Substitute document

Subject: AB/115/19/DOC

REPLACEMENT WINDOW DETAILS -
SCALE 1:10

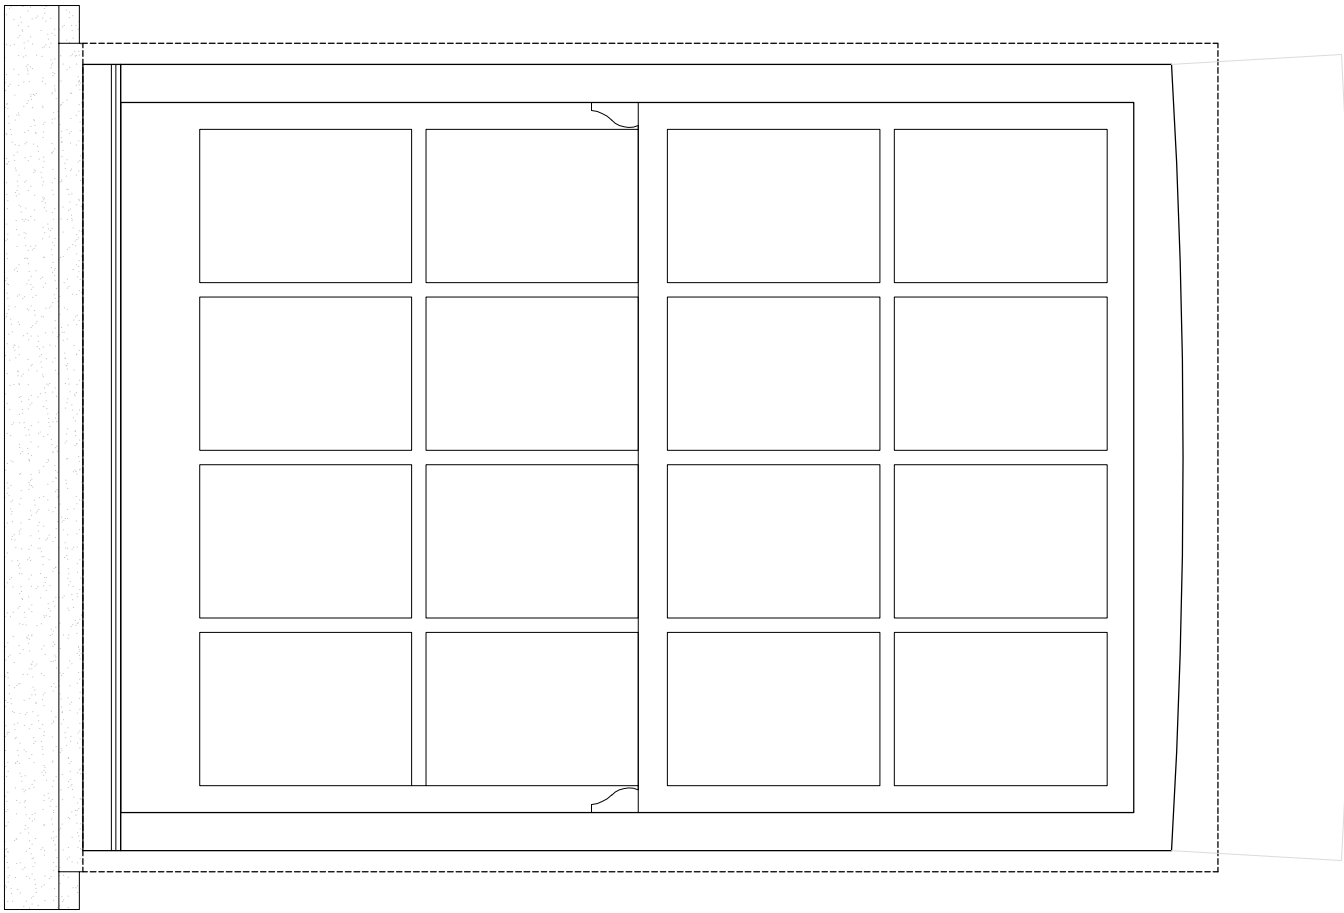
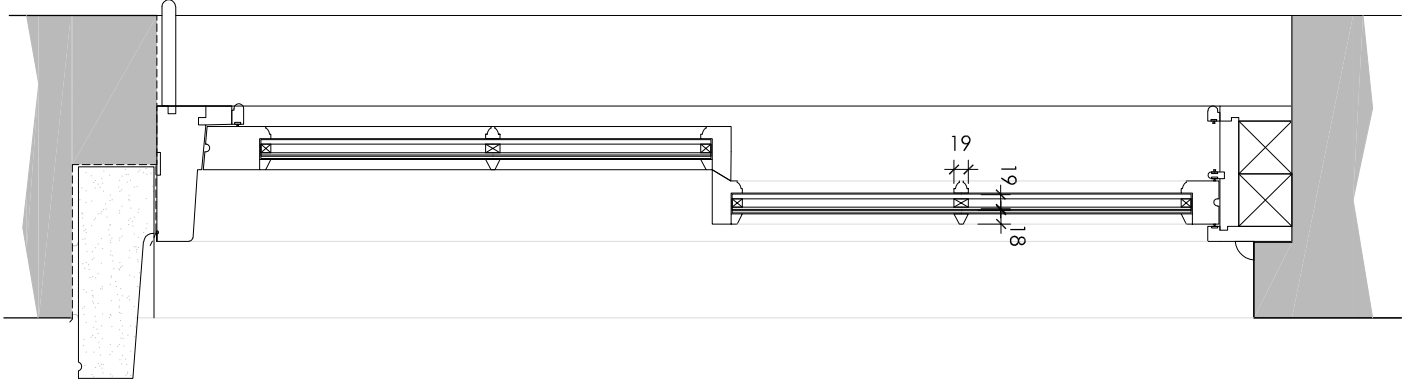
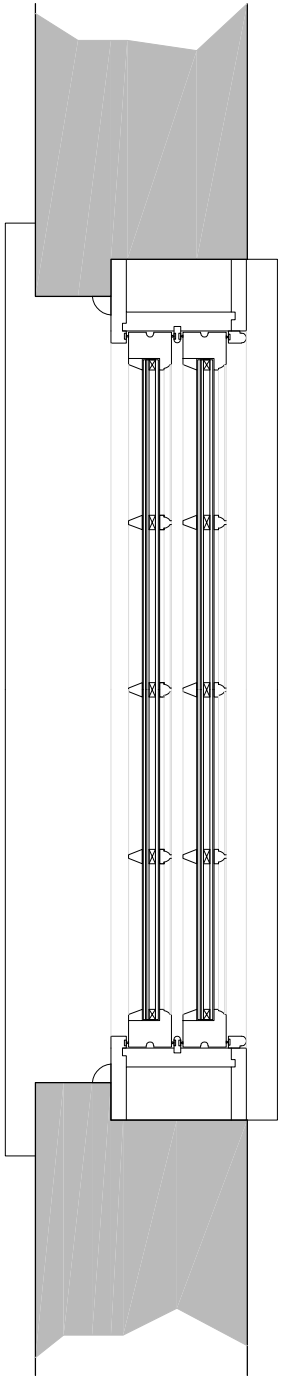
- I note that two options re provided regarding the work to the mansard roof, and I believe that the applicants preferred approach is also mine. This is based on the fact that it is more discrete. It is assumed that the structure would still be able to breath and meet the various building regulations.
 - Reference is made to the use of machinery for removing existing pointing etc. whilst it is noted that this is subject to conditions such as sample tests and experienced contractors, this is of concern – I work on the principal that hand tools cause less damage and are therefore more suitable.
 - Is the colour of the external joinery to match the existing – I can't see any references to this in the application.
-

- With regards to joinery colour, It hasn't quite been decided on the precise colour but it is envisaged that the front doors will likely be painted grey and the windows will likely be an off-white rather than the existing brilliant white.
